STORMWATER MANAGEMENT PLAN

OWL MARKETPLACE LOT 4

October 21, 2024

EPC PCD File No: PPR **2439**

**INITIAL GRADING  
& EROSION  
CONTROL PLAN**

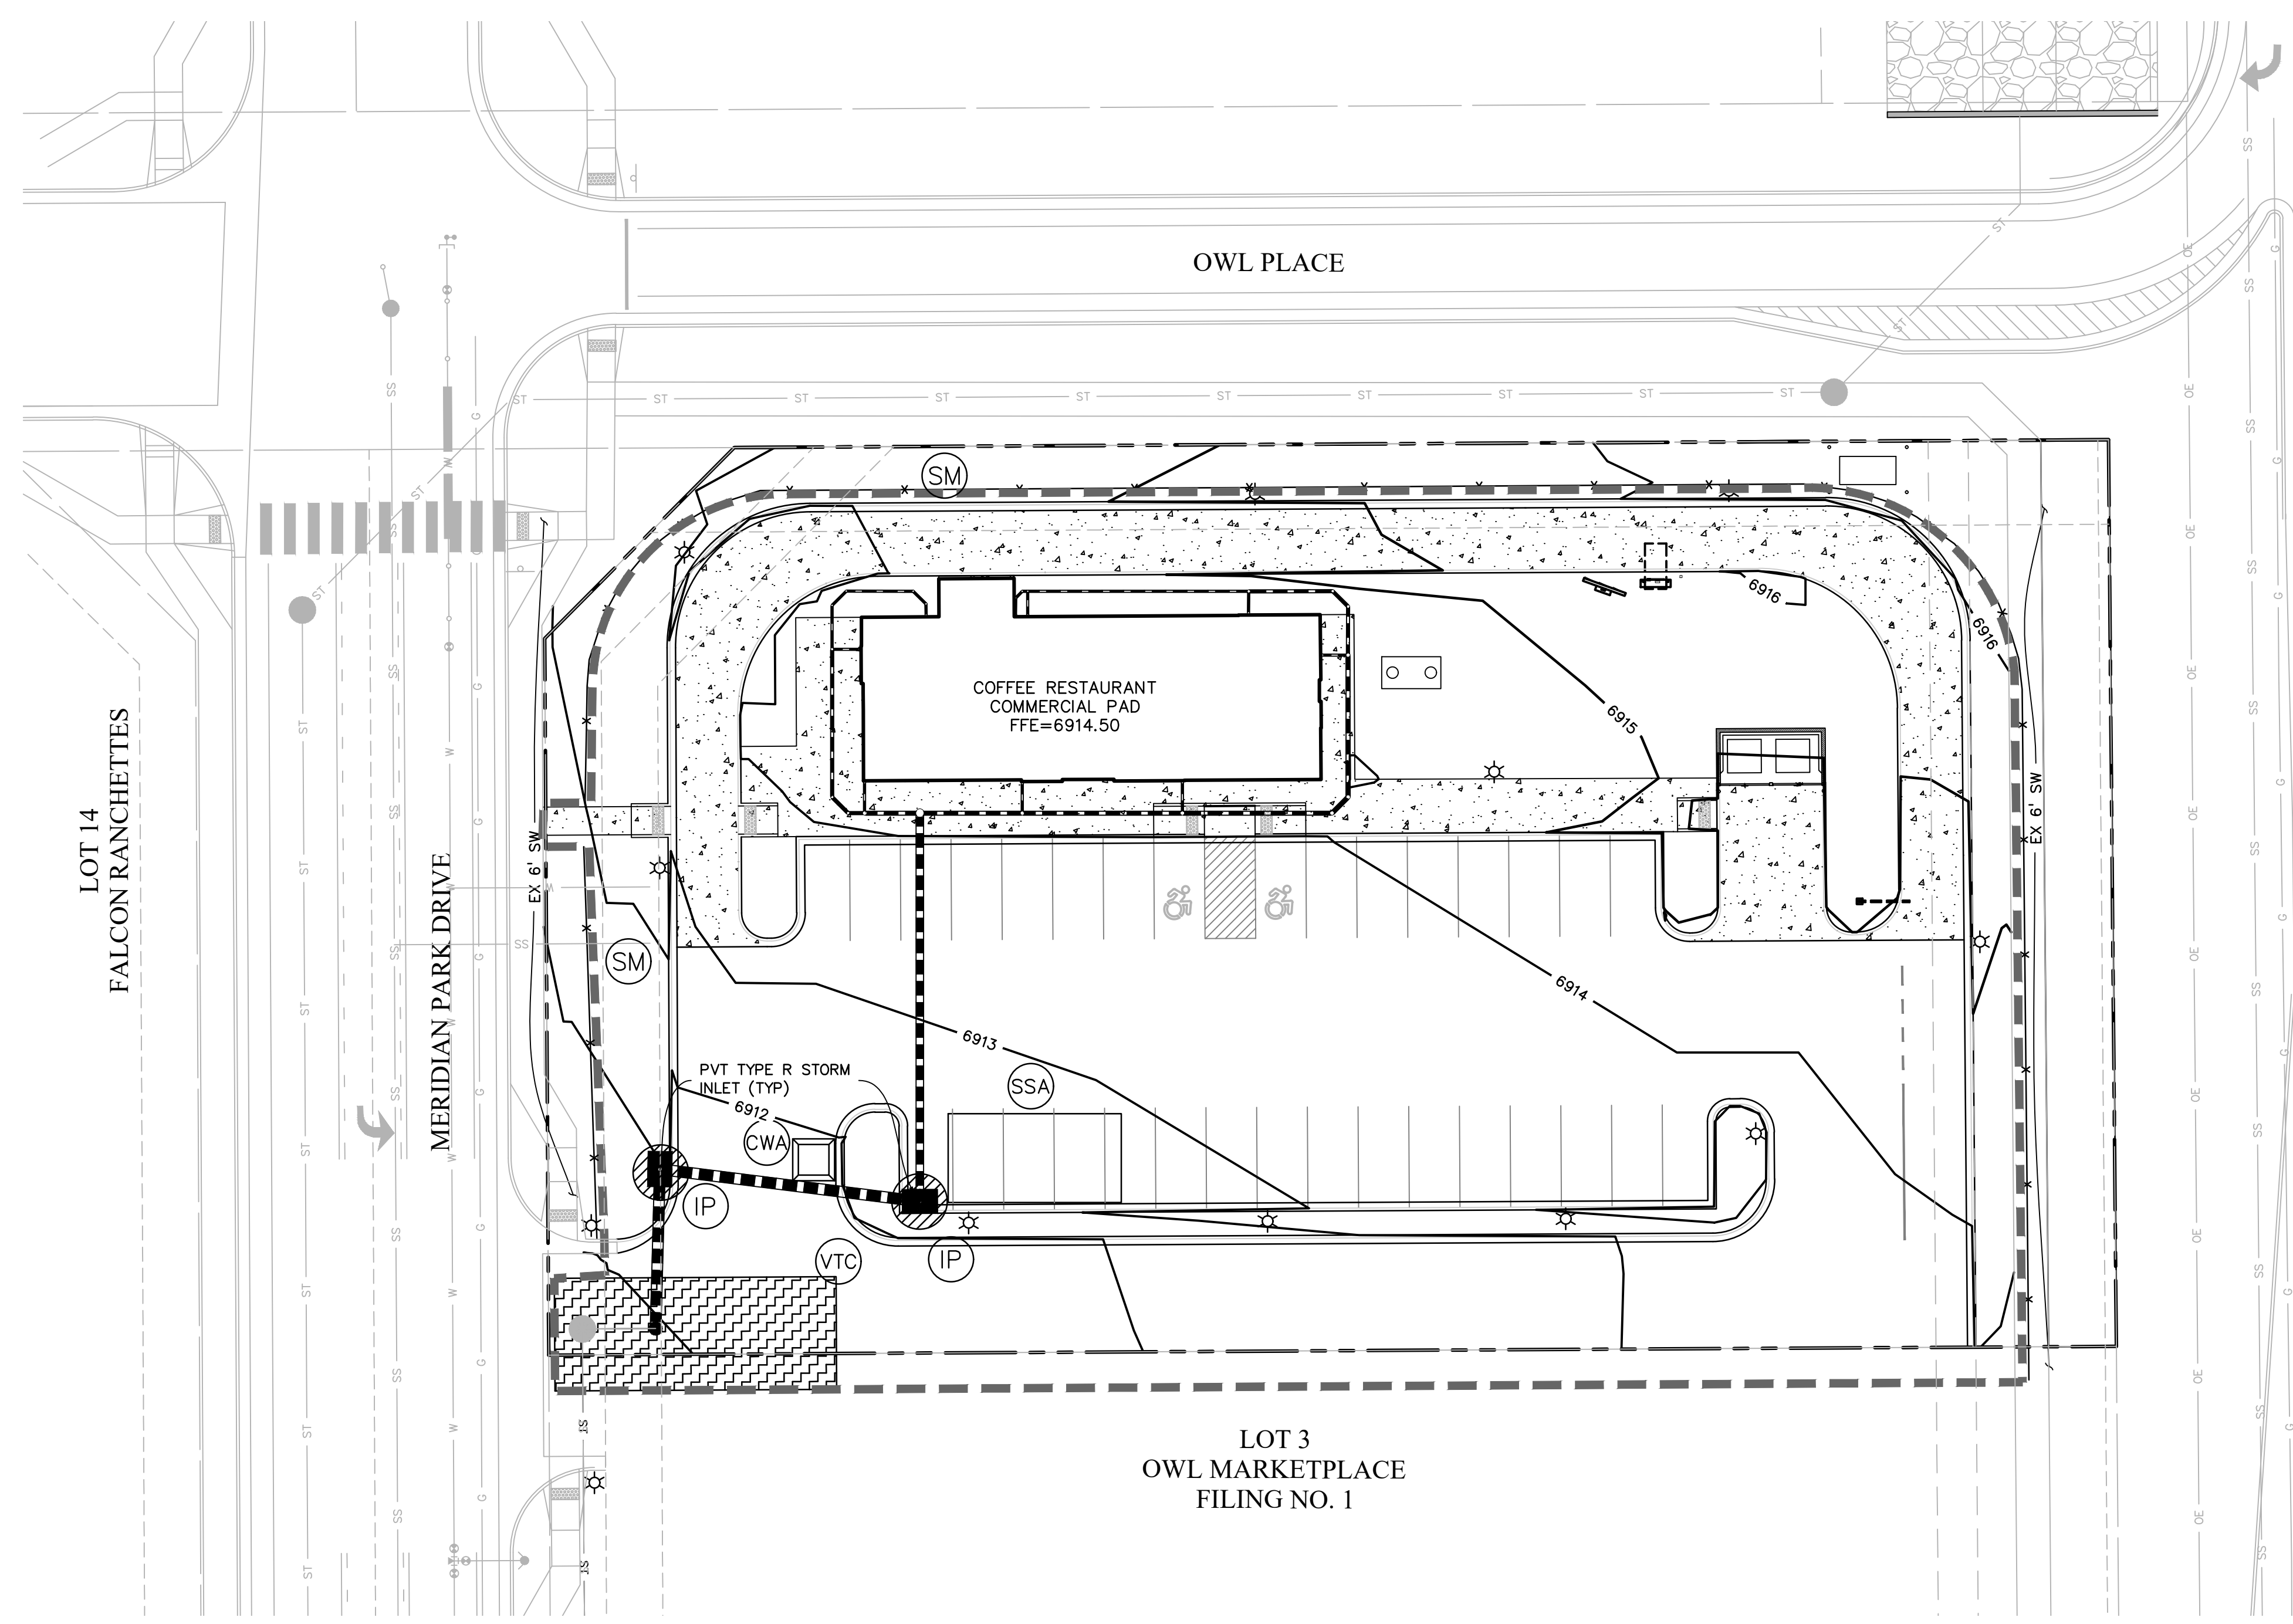
Item 18. Straw wattles and check dams are not shown on the GEC Plan. Update to accurately reflect planned control measures per the submitted GEC Plan (i.e., silt fence, inlet protection) 6

TSB is not anticipated on site per submitted GEC plan. Revise SWMP or GEC Plan accordingly.
